February 17, 2015

RE: Lazy Dog Restaurant, Addison Texas – Civil Engineering Revisions – Delta 3

Sheet 5.0 Utility Plan

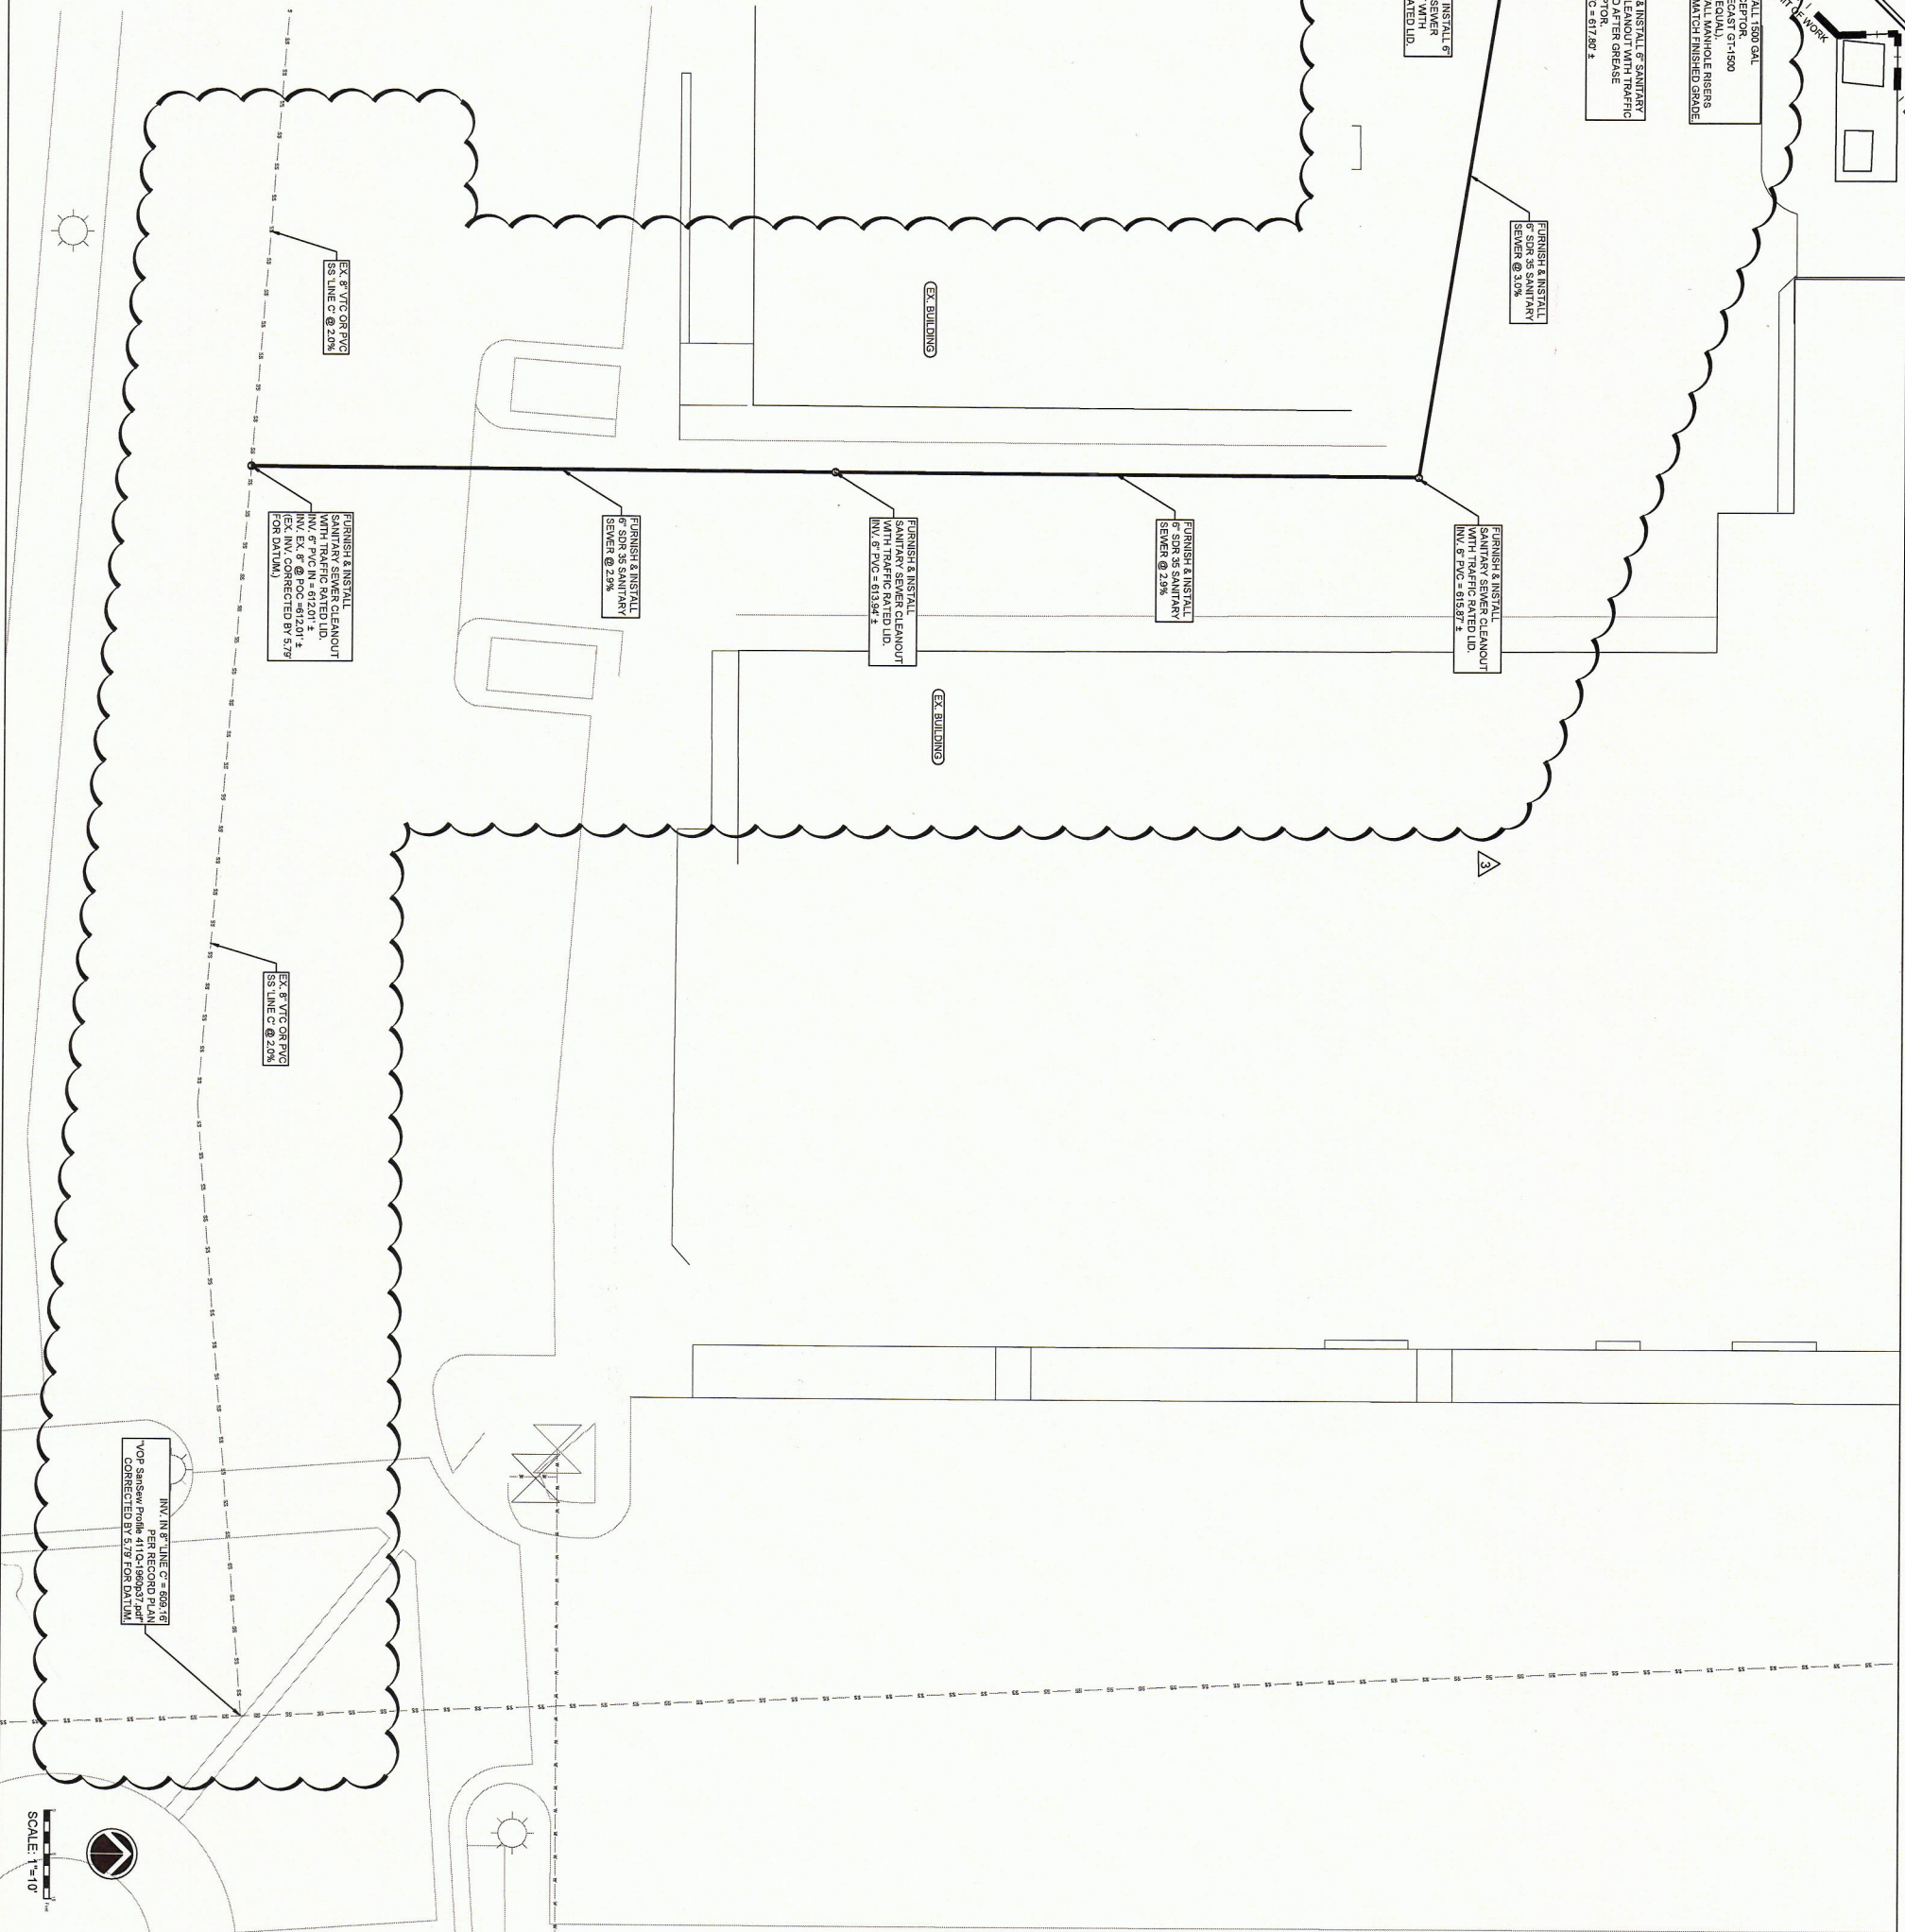
We have created Sheet C5.0A Utility Plan to show the new 6" sanitary sewer lateral connection to the existing 8" sanitary sewer main in the drive aisle south of the project site. Based upon the record plans, and the year the plans were prepared, we have corrected the inverts on the existing 8" line by 5.79' for the differences in datum. This was confirmed against the ALTA provided on September 18, 2014 and the record drawing "VOP SanSew Profile 411Q-1960p37.pdf.

1. Inverts provided into and out of the new Lazy Dog grease interceptor. Please note the manholes on the grease interceptor shall be fitted with risers, per manufacturer recommendations, to bring the manhole access to match finished grade.
2. Added approximately 197 linear feet of 6" SDR 35 sanitary sewer line at approximately 3% slope to connect to the existing 8" sanitary sewer line.
3. The new 6" line is located approximately 7.5' off the face of the westerly building. This may be adjusted 1-2 feet west/east in the field as needed based upon existing conditions encountered. Contractor to as-built exact location. Deviations greater than the 1-2 feet shall be approved by the owner.
4. Added 3 new sanitary sewer cleanouts with traffic rated lids.
